17-23 Church Street.

**From:** Roger Evans  
**Sent:** 23 May 2012 12:01  
**To:** Lisa Hughes  
**Subject:** S6/2012/0719/MA + S6/2012/0720/CA

Roger Evans  
Environmental Health Officer

DRAWING TITLE:
 Zone 2
 Elevations

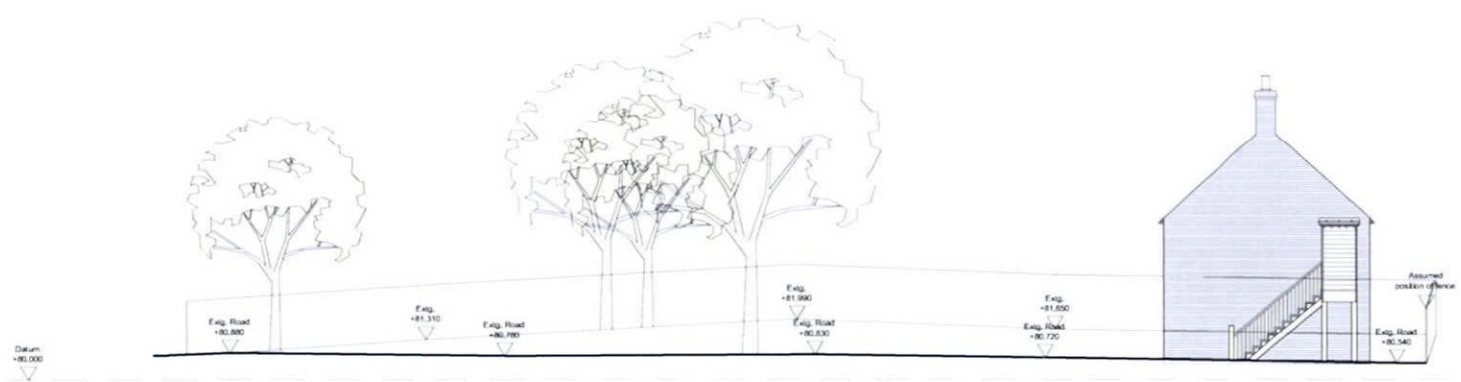
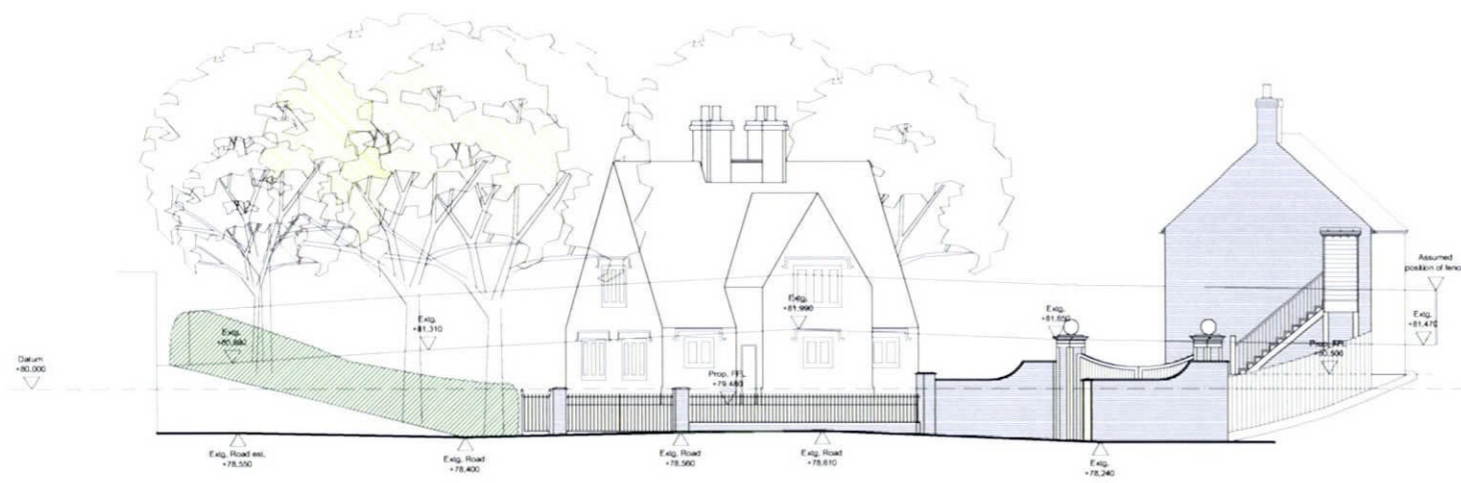
- In zone 2 the 3 bedroom house is close enough to the Great North road for me to have some noise concerns. I think a condition needs to be imposed requiring an acoustic report and, if necessary details of attenuation approved prior to development. – *Prior to the commencement of the development, the developer should submit to the Local planning Authority a noise report. The report should include details of the noise exposure on the site, an assessment of the internal noise levels for habitable rooms and external amenity space. Where these levels will exceed the good standard indicated in BS8233 for internal noise levels and the WHO 55dBA<sub>Leq</sub> for amenity space, a scheme of attenuation shall be submitted for approval. Where this scheme involves reliance on closed windows to achieve the required attenuation levels, details of alternative ventilation, capable of providing background and rapid ventilation levels shall also be submitted.*
